16 December 2020

NSW Department of Planning, Industry & Environment  
Modification Assessments  
GPO Box 39  
SYDNEY NSW 2001

**WINE COUNTRY DRIVE (MR220): MP10\_0137 MOD 14 – RESPONSE TO SUBMISSIONS, MODIFICATION TO MAJOR PROJECT APPROVAL FOR HUNTLEE NEW TOWN, STAGE 5 (LARGE LOTS)**

LARGE LOT RESIDENTIAL
SCALE 1:3500

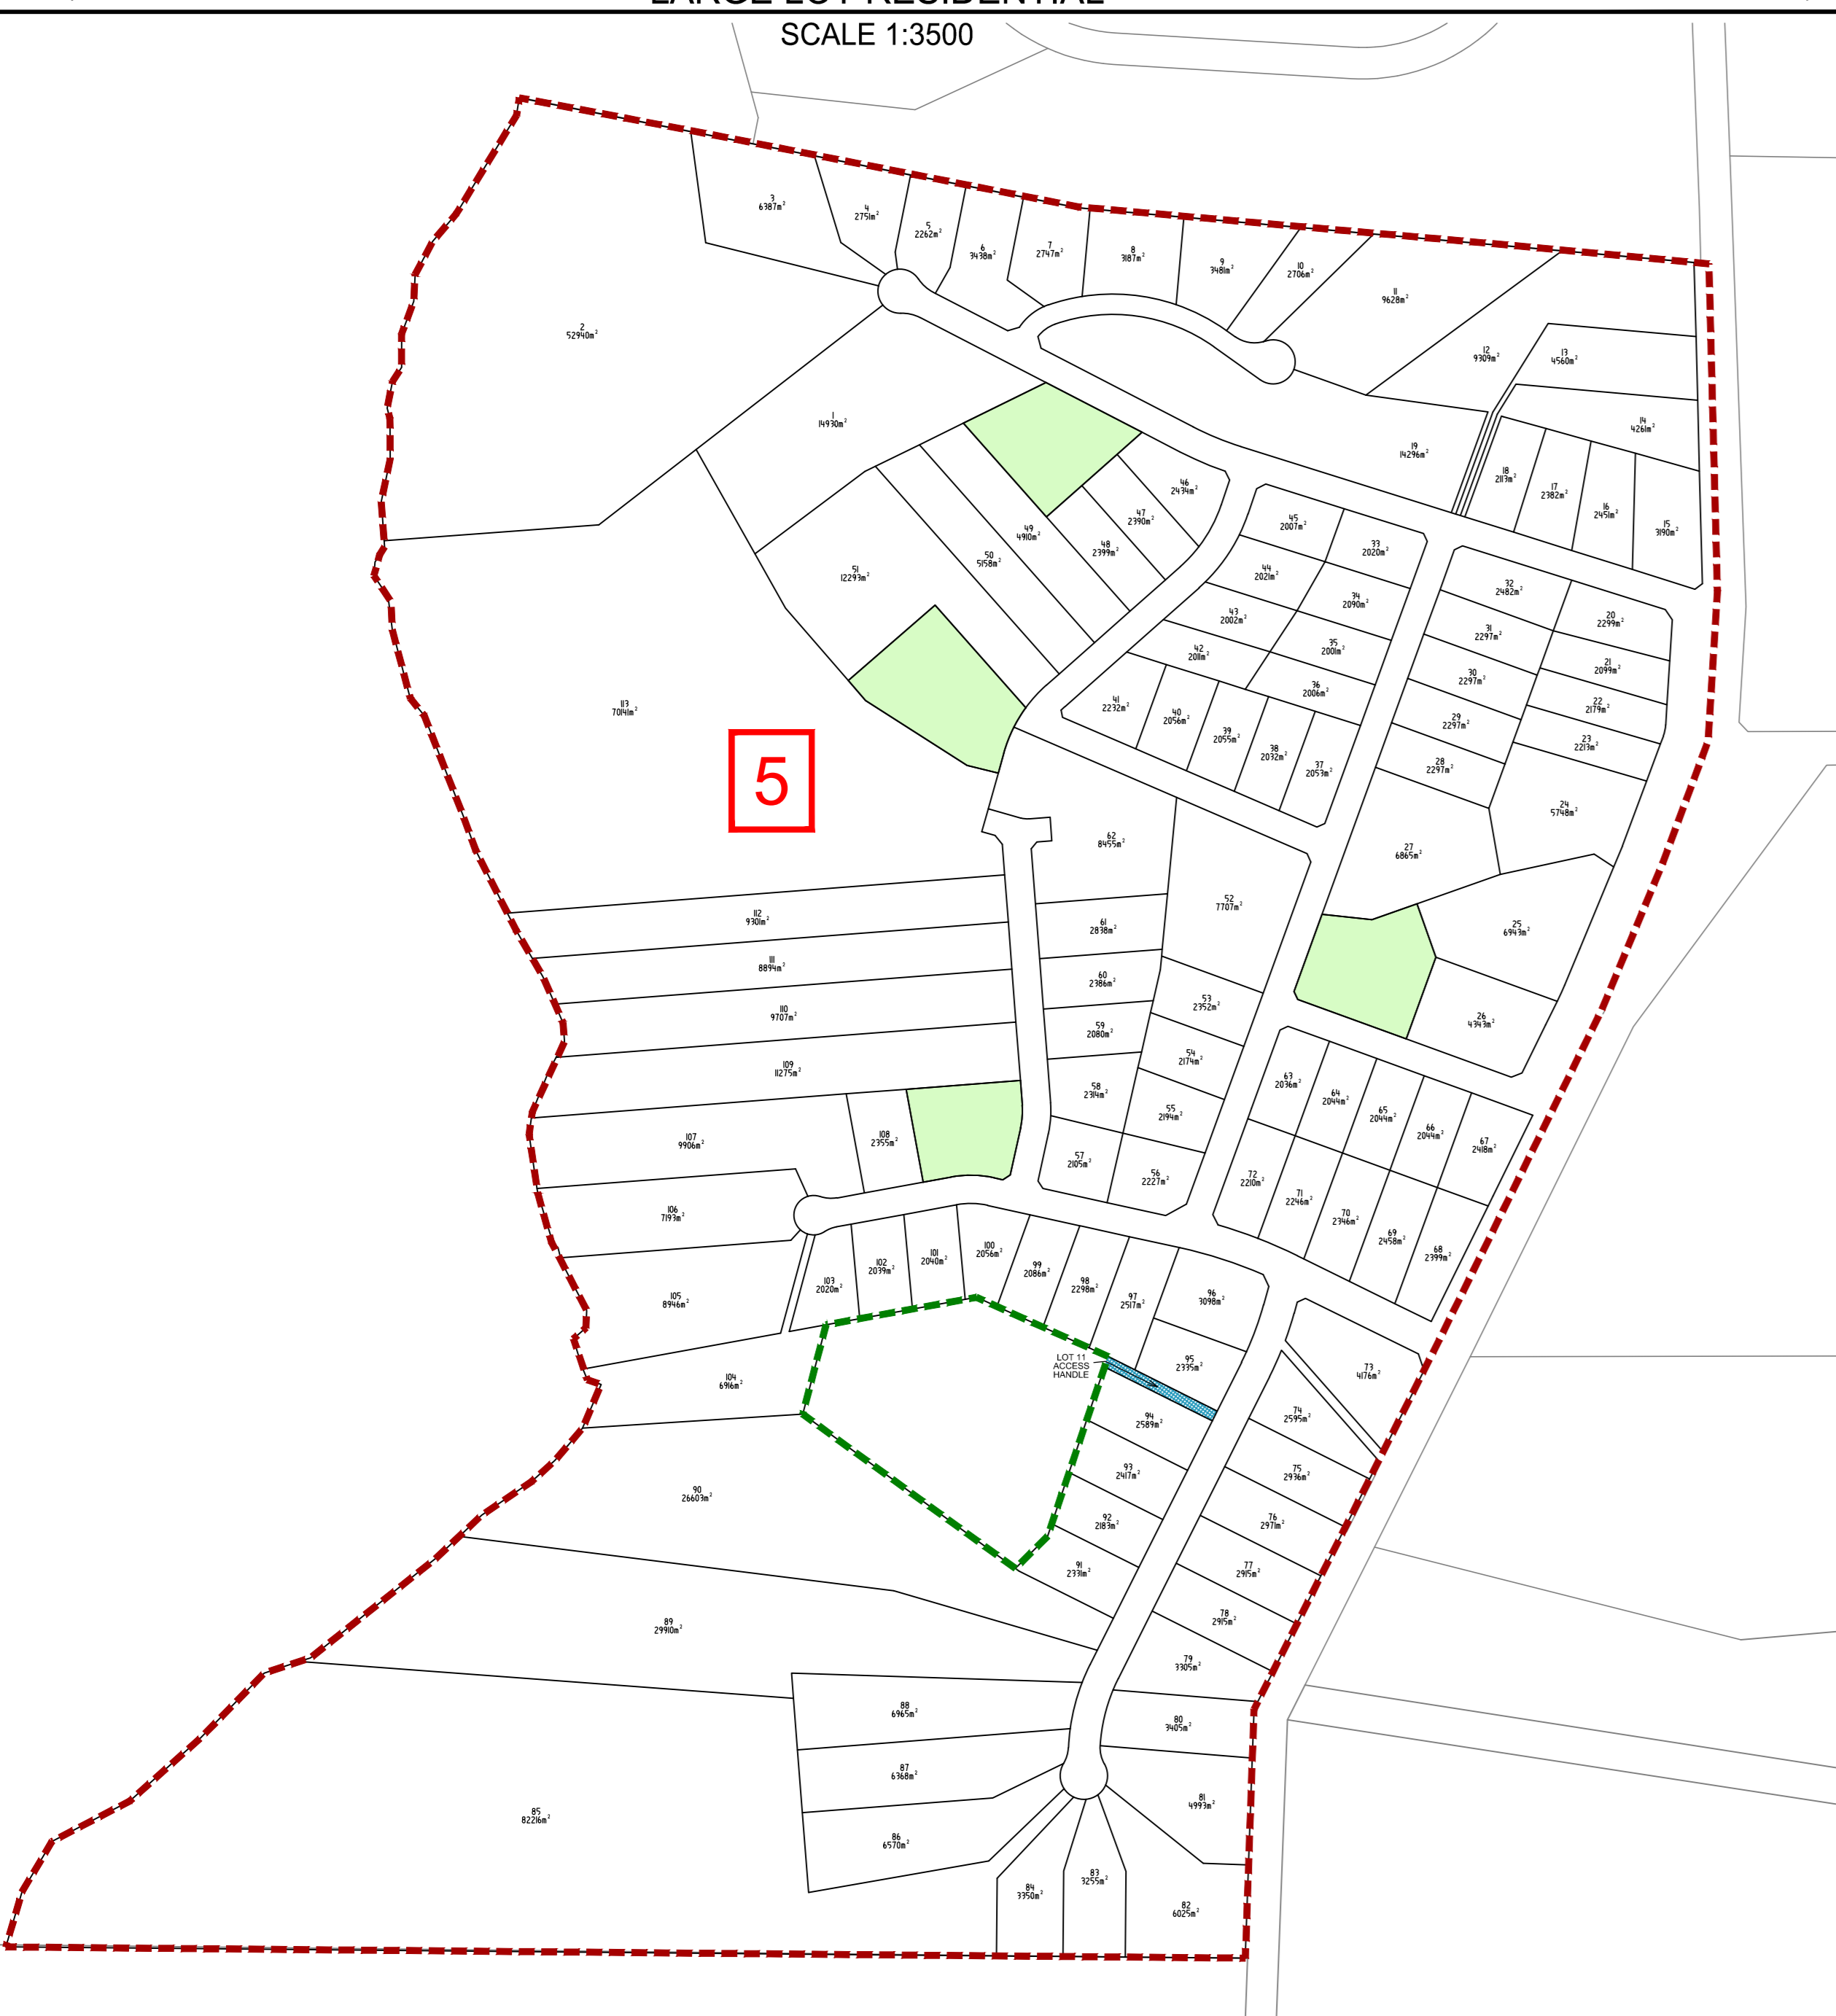
- TfNSW will require a restriction be placed on any proposed lots that have a boundary to Wine Country Drive to ensure that no direct access is provided between these lots and the classified State road corridor. On the provided plans, these are lots 12 to 15, 67, 68, 73 to 82.
